Our Case Number: ACP-322958-25

An
Coimisiún
Pleanála

Date: 05 January 2026

Re: Athlone link road phase 2. Proposed link road, joining the Crescent Junction (R915) to Southern Station Road Junction
Athlone, County Westmeath

DRAWING No: 120278-501

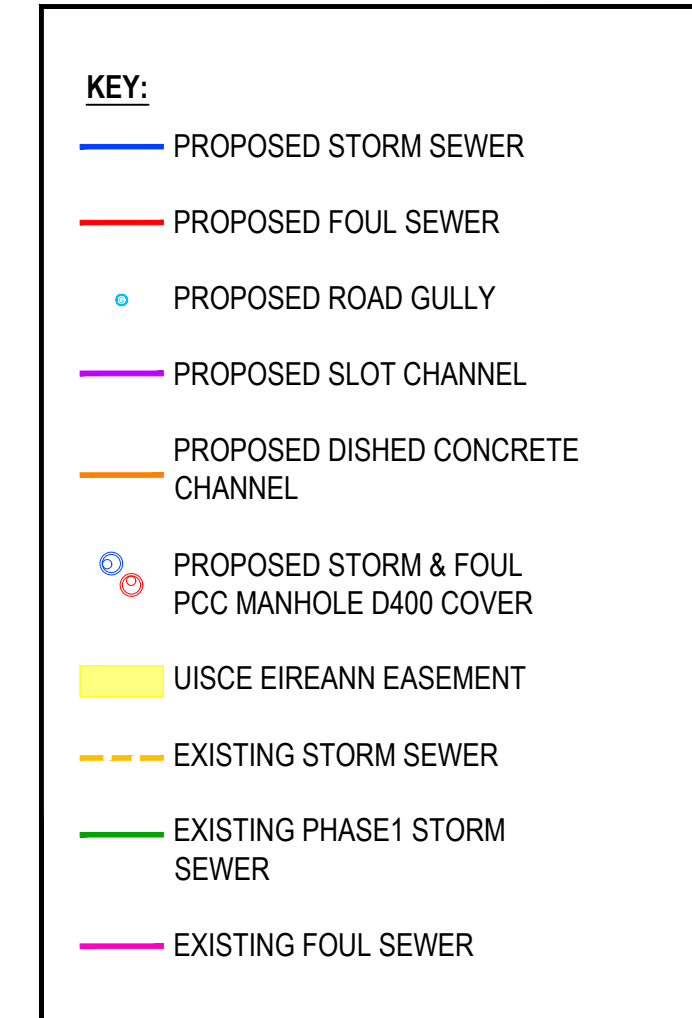
1. The application Drainage Report refers to shallow channels as draining the western side of the site and the immediate areas to the north and south. This Drainage Report also states that the application site is on occasion subject to flooding and that despite sizing the proposed surface water drainage infrastructure to accommodate all storm durations and intensities up to a 1:30 year storm (plus a 20% climate change factor), during exceptional events in excess of this water levels may overtop the discharge control (hydrobrake) and result in short-term uncontrolled flows towards the culvert draining west under Southern Station Road, towards an area that is noted to be prone to flooding under the Shannon Catchment Flood Risk Assessment and Management Study. The Westmeath County Development Plan 2021-2027, the operative statutory plan for this area, includes policy objective CPO 10.106 requiring flood risk assessments to be carried out for any development proposals within 200m of a watercourse and at risk of flooding. **The applicant is requested to submit a Site-Specific Flood Risk Assessment following the approach set out in 'The Planning System and Flood Risk Management Guidelines for Planning Authorities' (2009), including the Technical Appendices.**
